Matter raised during the Open Floor Hearing (OFH1 – 30th September 2022) by Boreham Parish Council (Cllr Linda Reed) relating to the increased levels of traffic on the 2 country lanes which are the only access routes to the proposed entrance of the Longfield Solar Farm.

LEGEND	
	EXISTING CARRIAGEWAY
	HIGHWAY BOUNDARY
	INDICATIVE CARRIAGEWAY WIDENING

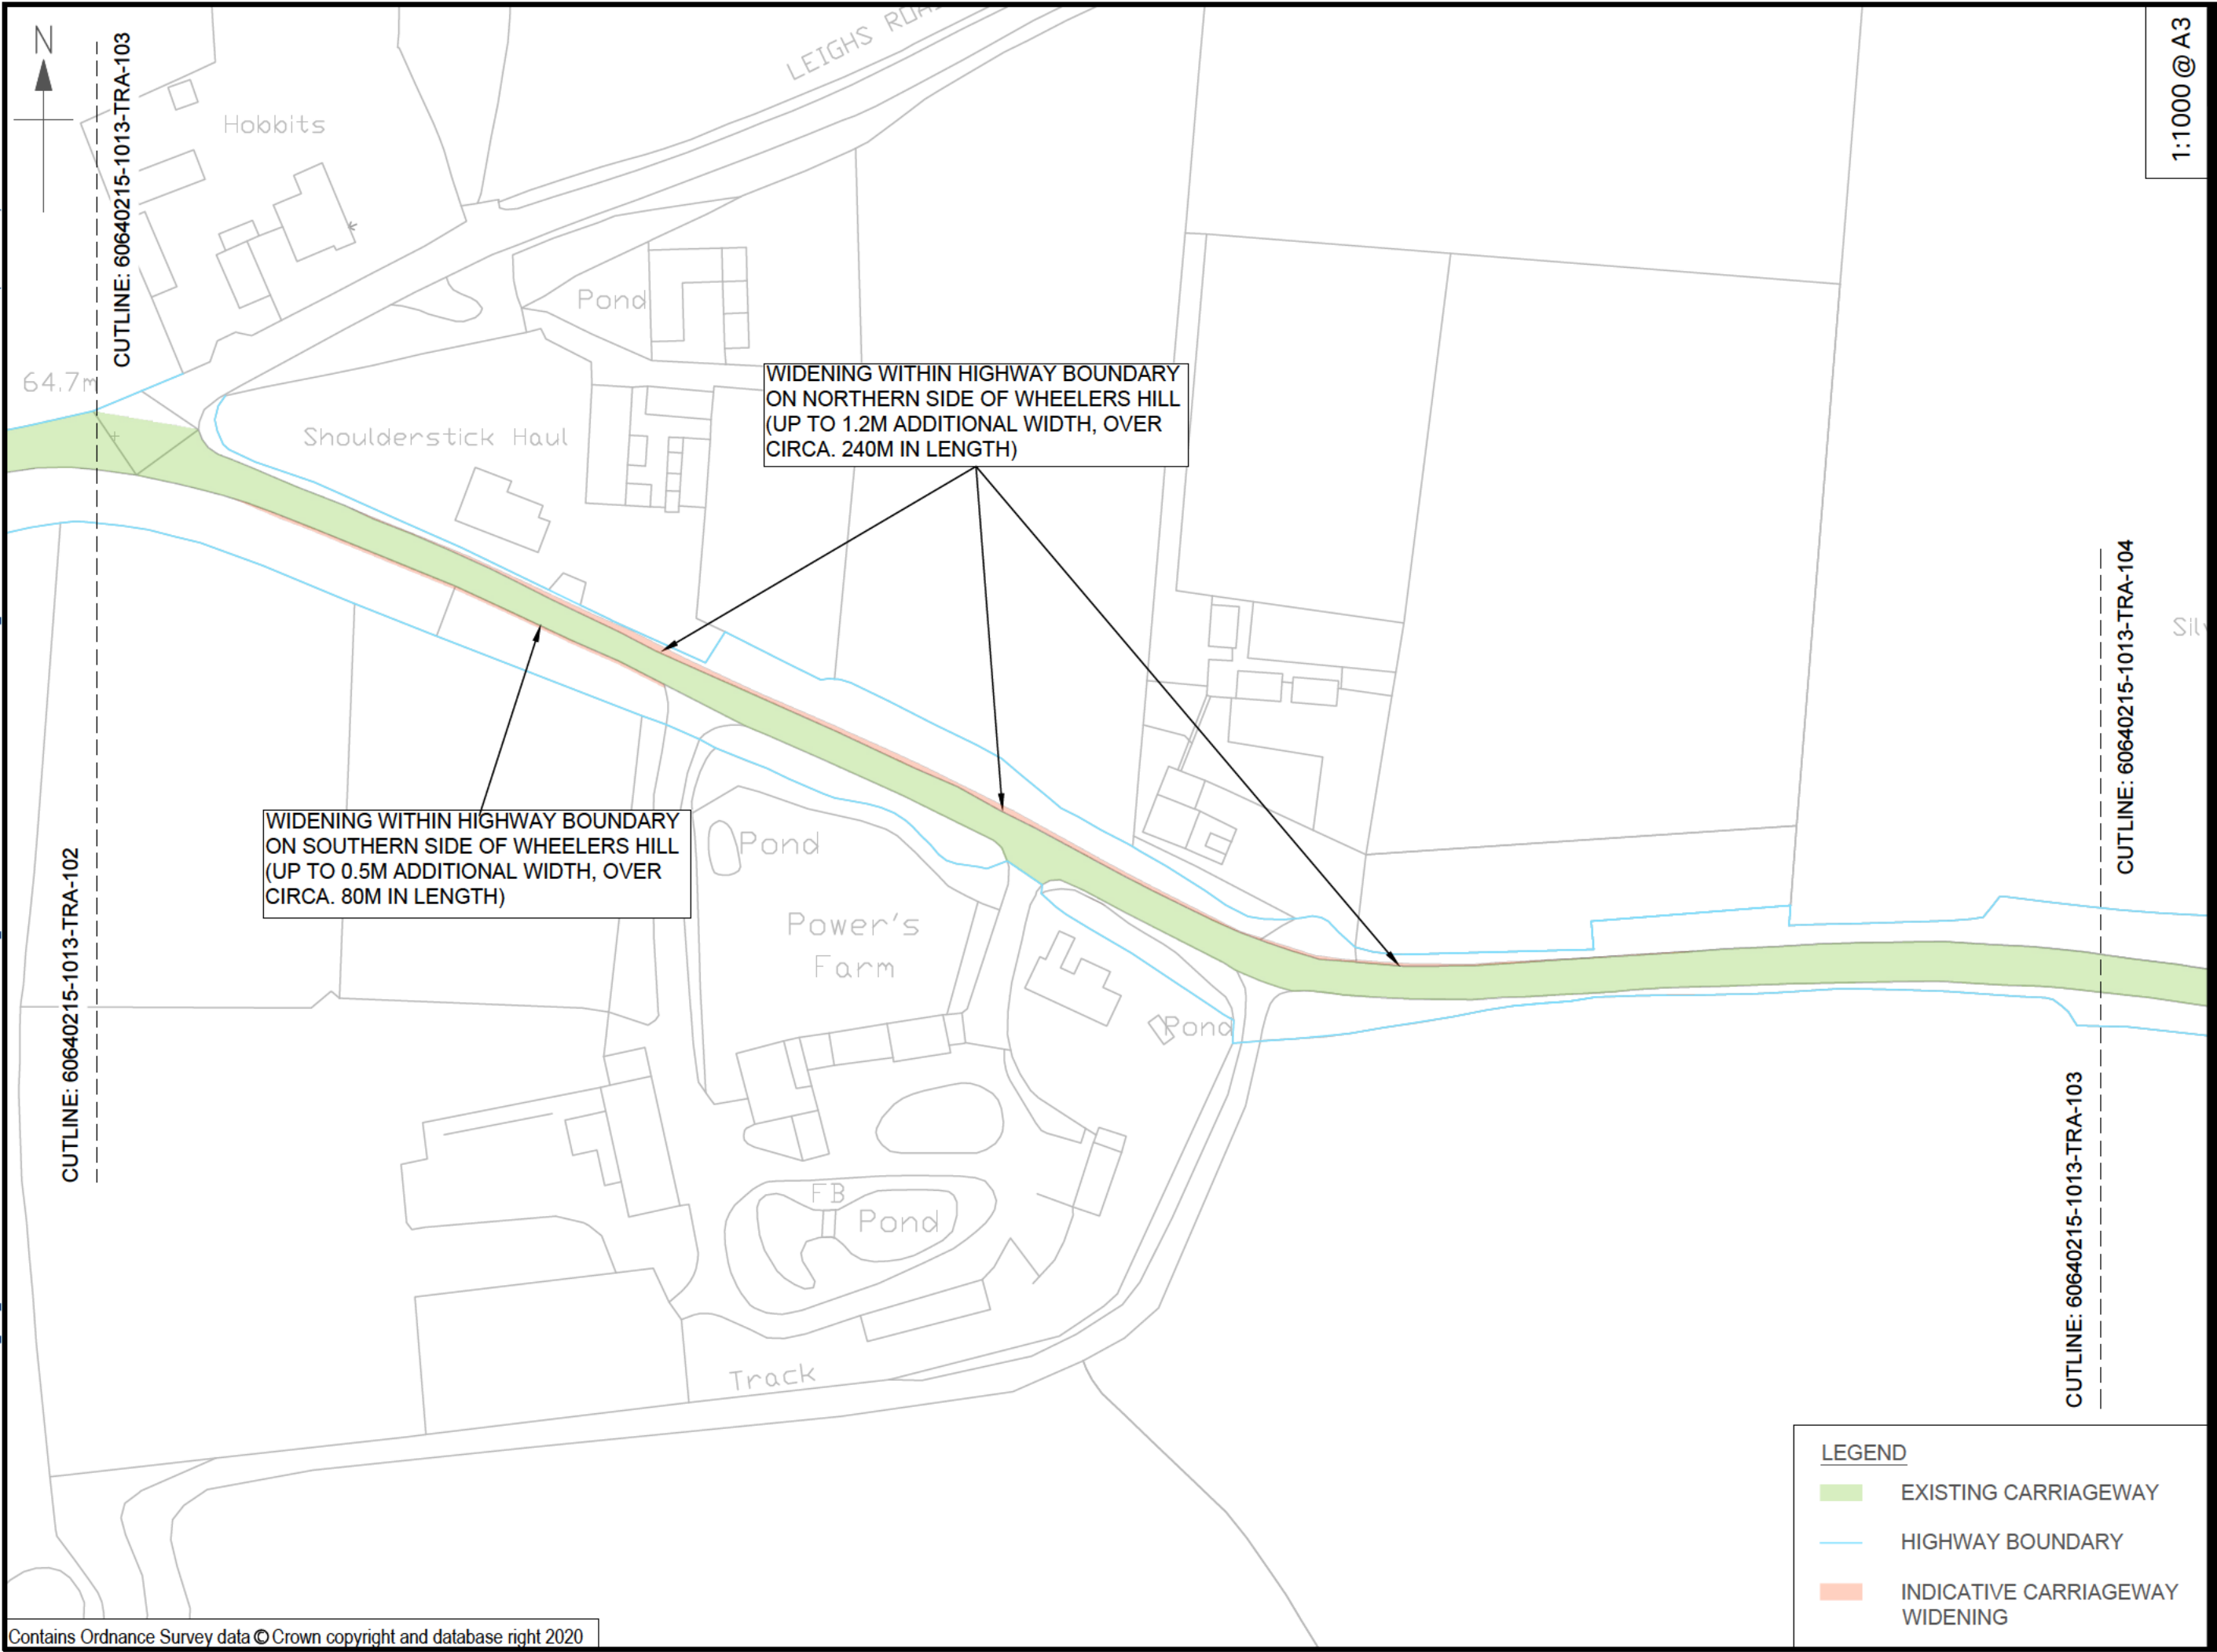
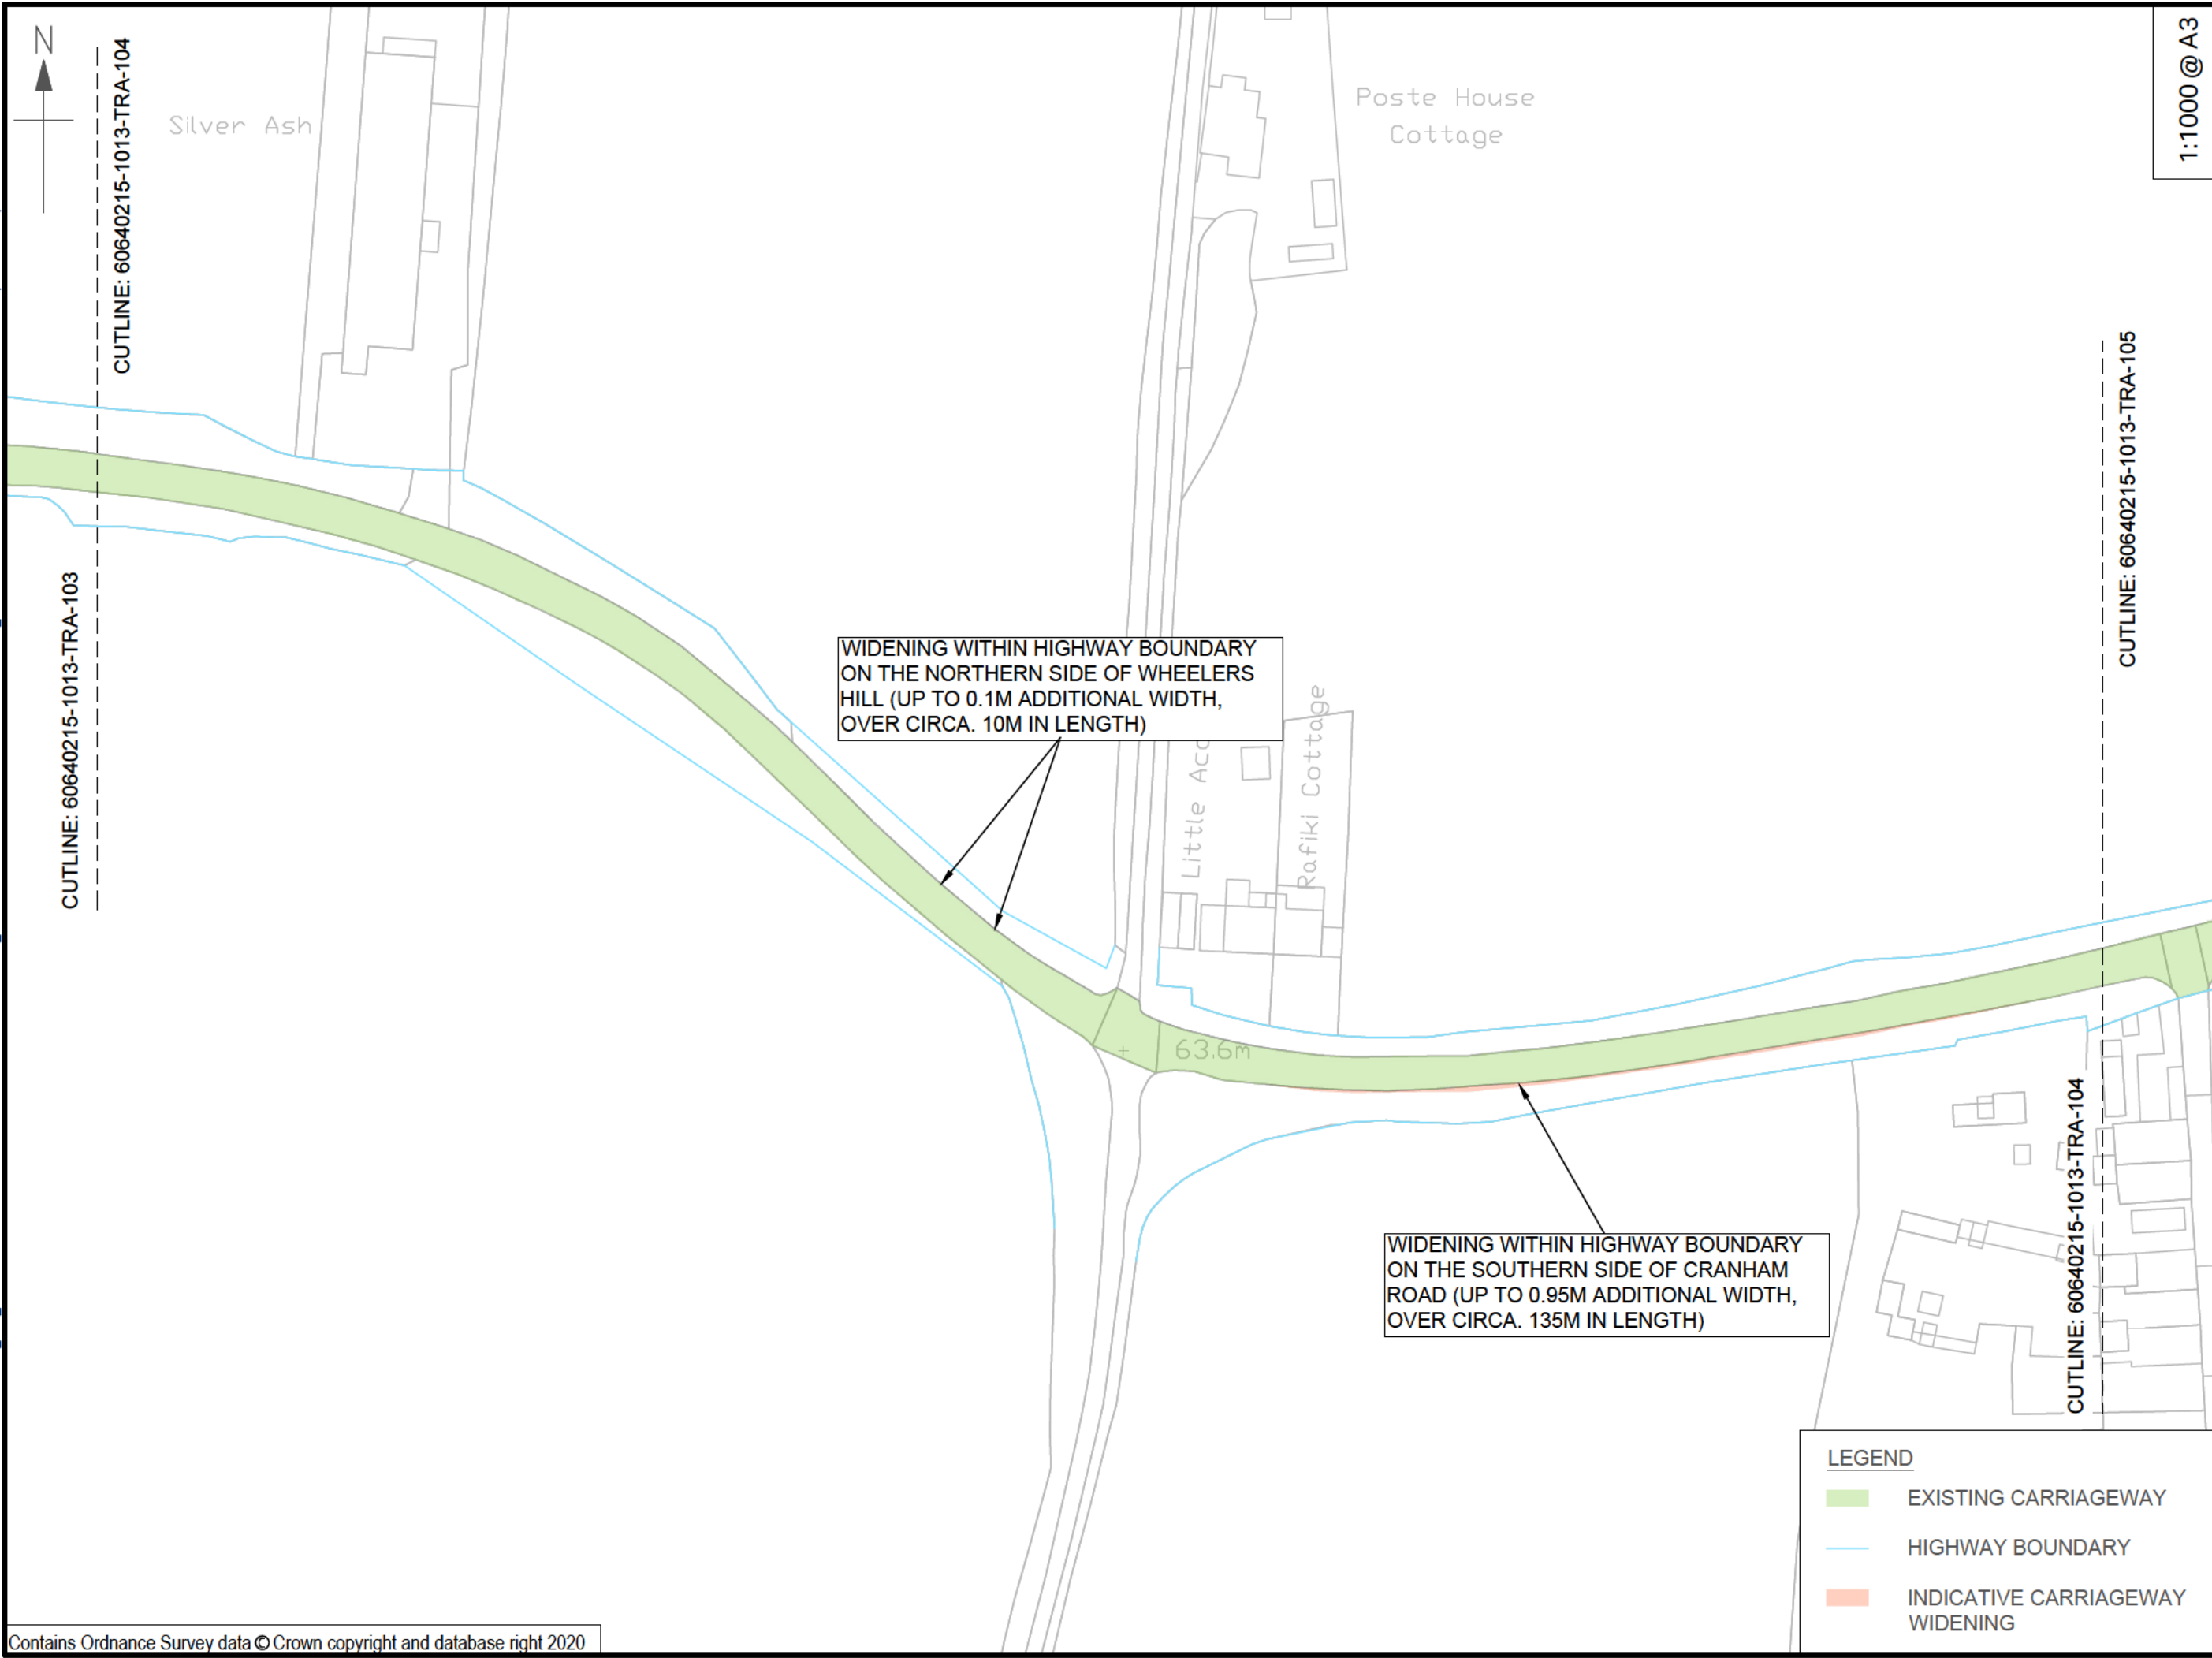
The developer's preferred route to the Longfield site is via Cranham Road and Wheelers Hill. This is country lane which, even following the proposed widening is not deemed suitable for the type traffic anticipated during the implementation phase at Longfield. This route will also be impacted by the construction of the Chelmsford North East Bypass (CNEB). The only other route to the site is via Main Road, Boreham and Waltham Road. It is the stated intention of the developer not to use this route. However, it is likely that there will be times throughout the implementation phase and beyond where this will be necessary due to blockage, delay or temporary closure affecting the preferred route or other routes leading to it. These incidents do occur from time to time.
